**Our Case Number:** ABP-314610-22

**Re:** BusConnects Ballymun/Finglas to City Centre Core Bus Corridor Scheme  
Ballymun/Finglas to Dublin City Centre

## **BUSCONNECTS BALLYMUN/FINGLAS CORE BUS CORRIDOR SCHEME**

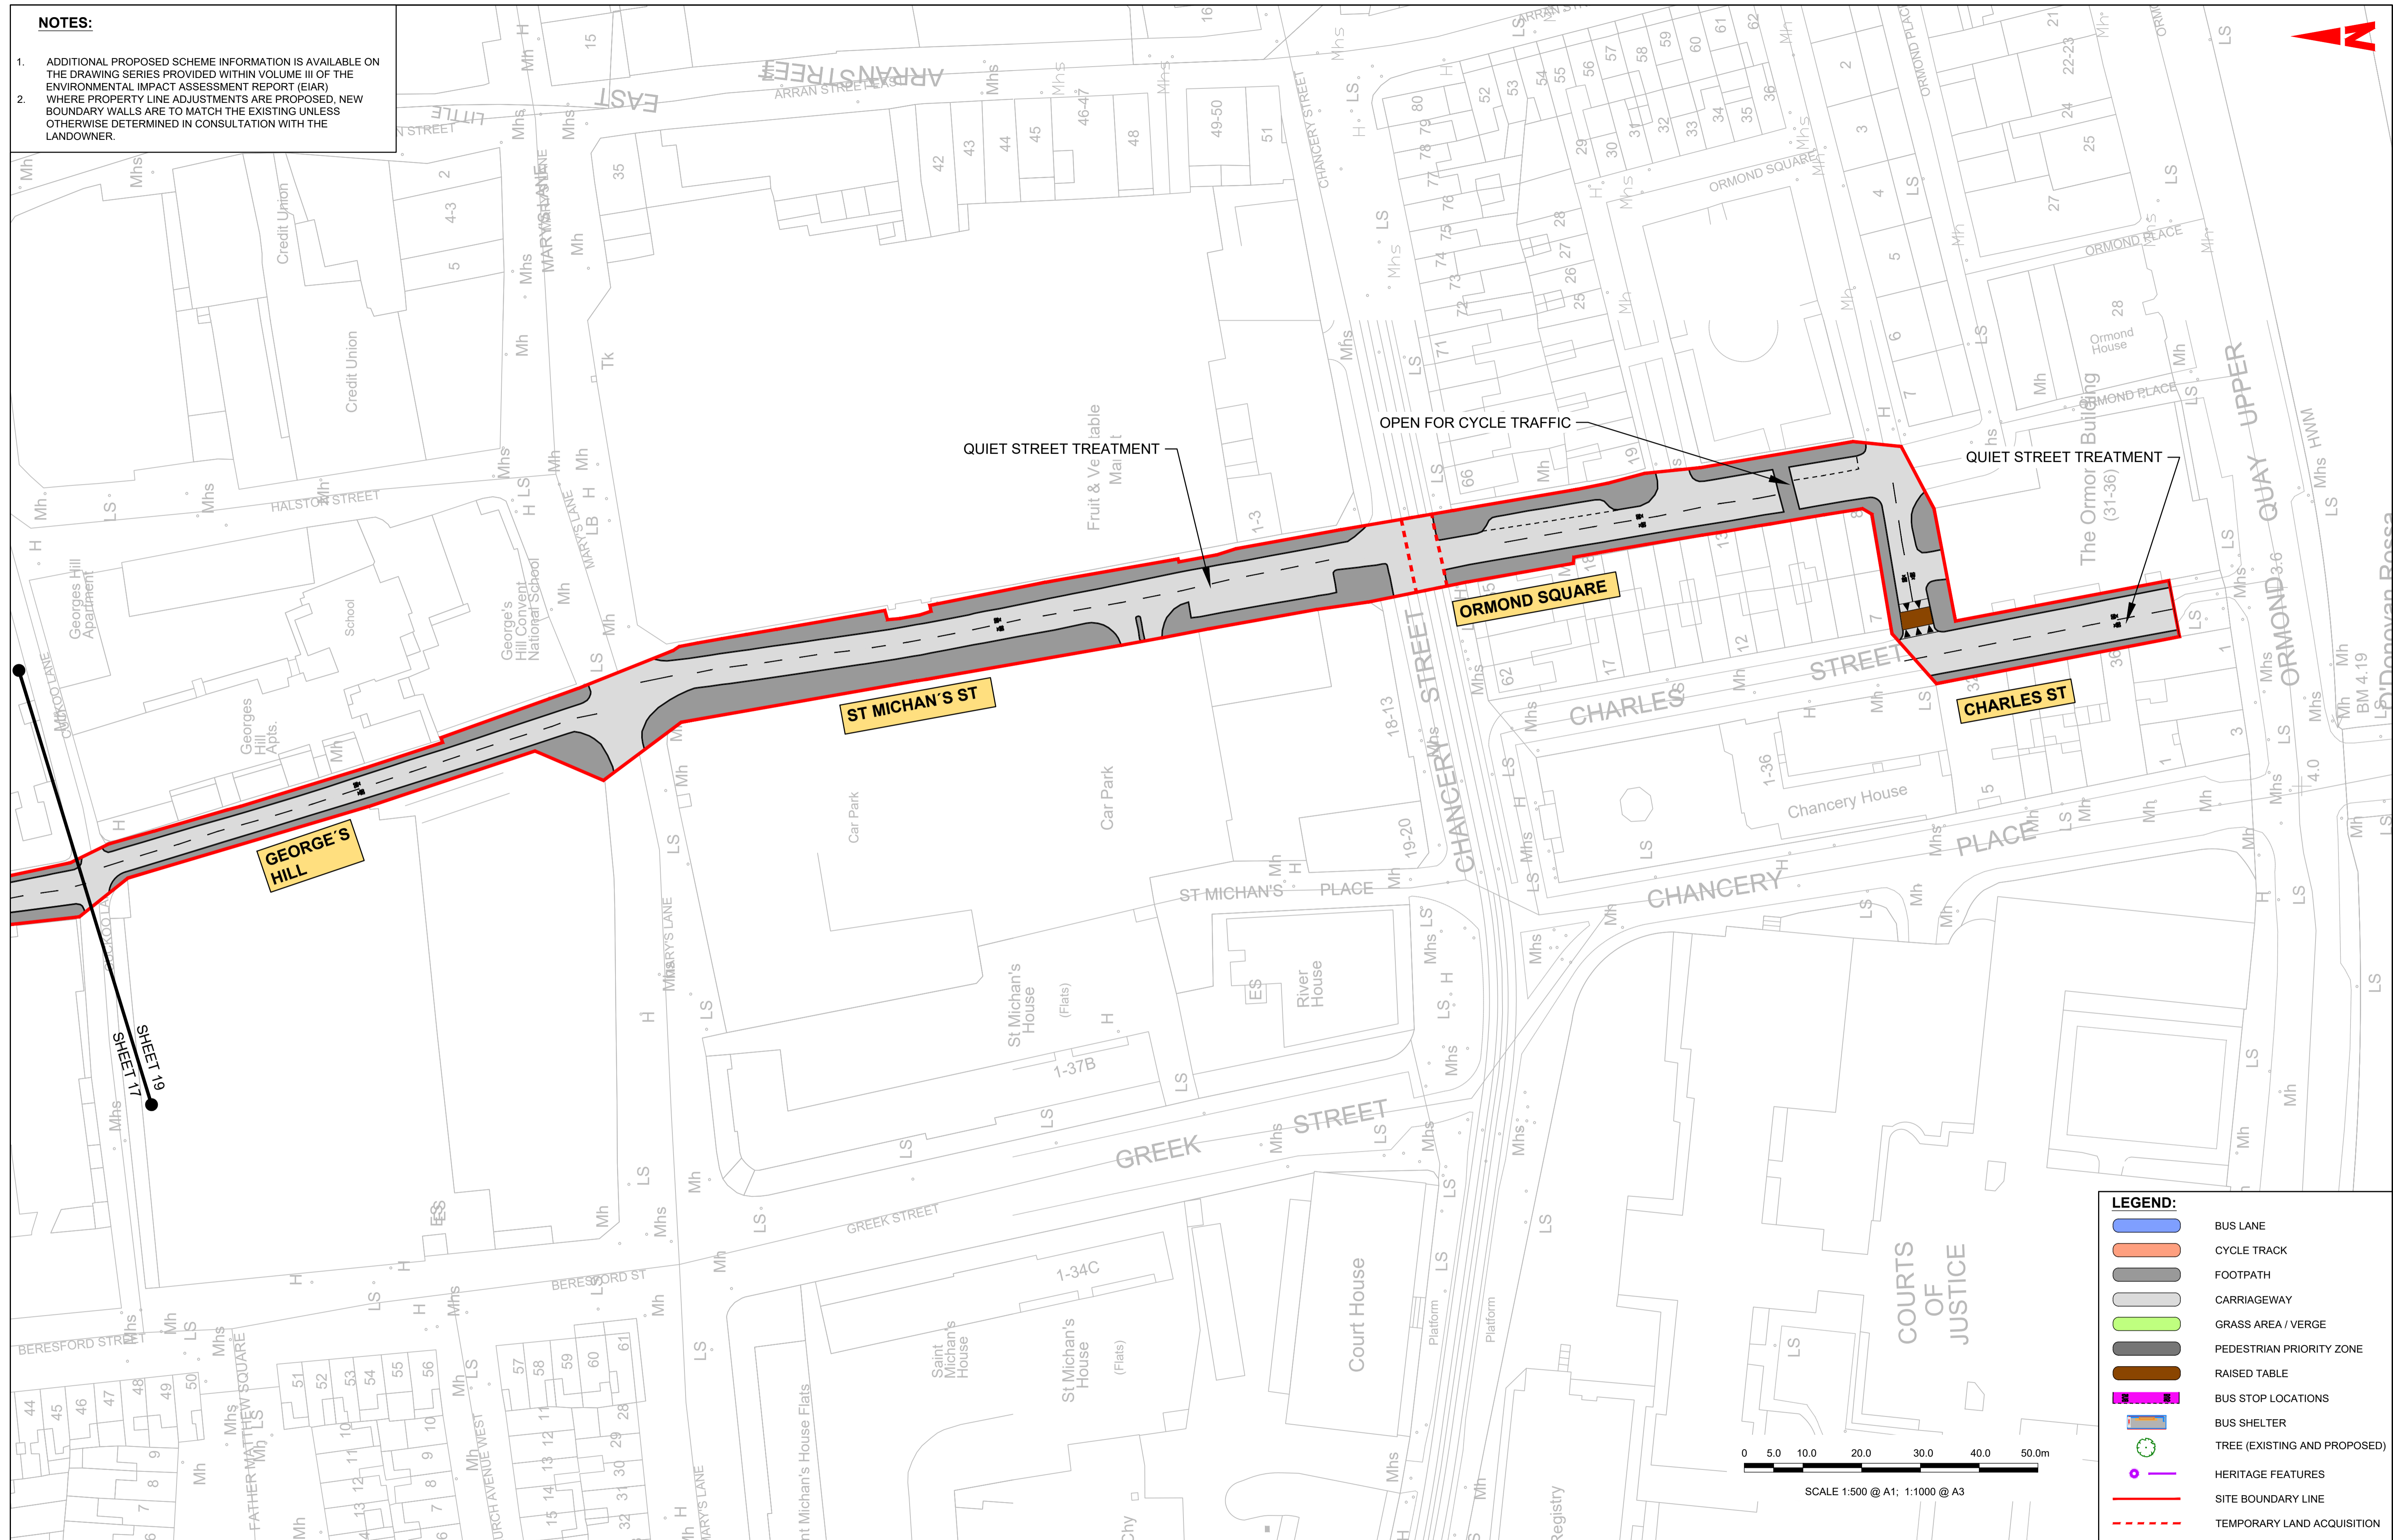
- Western Way/Constitution Hill (five stage)
- Arran Quay/Church Street (sheet 18)

- St. Pappin Road/Ballymun Road
- St. Canice's Road/ Ballymun Road
- Prospect Way/Finglas Road
- Mary's Lane/Church Street (sheet 18)
- Church Street/Finglas Road (sheet 27)
- Wellmount Road/Finglas Road
- Finglas Road (sheet 28)
- The Griffith/Finglas Road (sheet 30)
- Ballyboggan Road/Finglas Road
- Slaney Road/Finglas Road
- Claremont Court/Finglas Road

- Southern end of Church St (Sheets 17/18)
- Southbound on Ballymun Road (Sheet 20)
- Southbound on Botanic Road (Sheet 22)
- No cycling provision at all parallel to Finglas Road (Sheets 23-26)
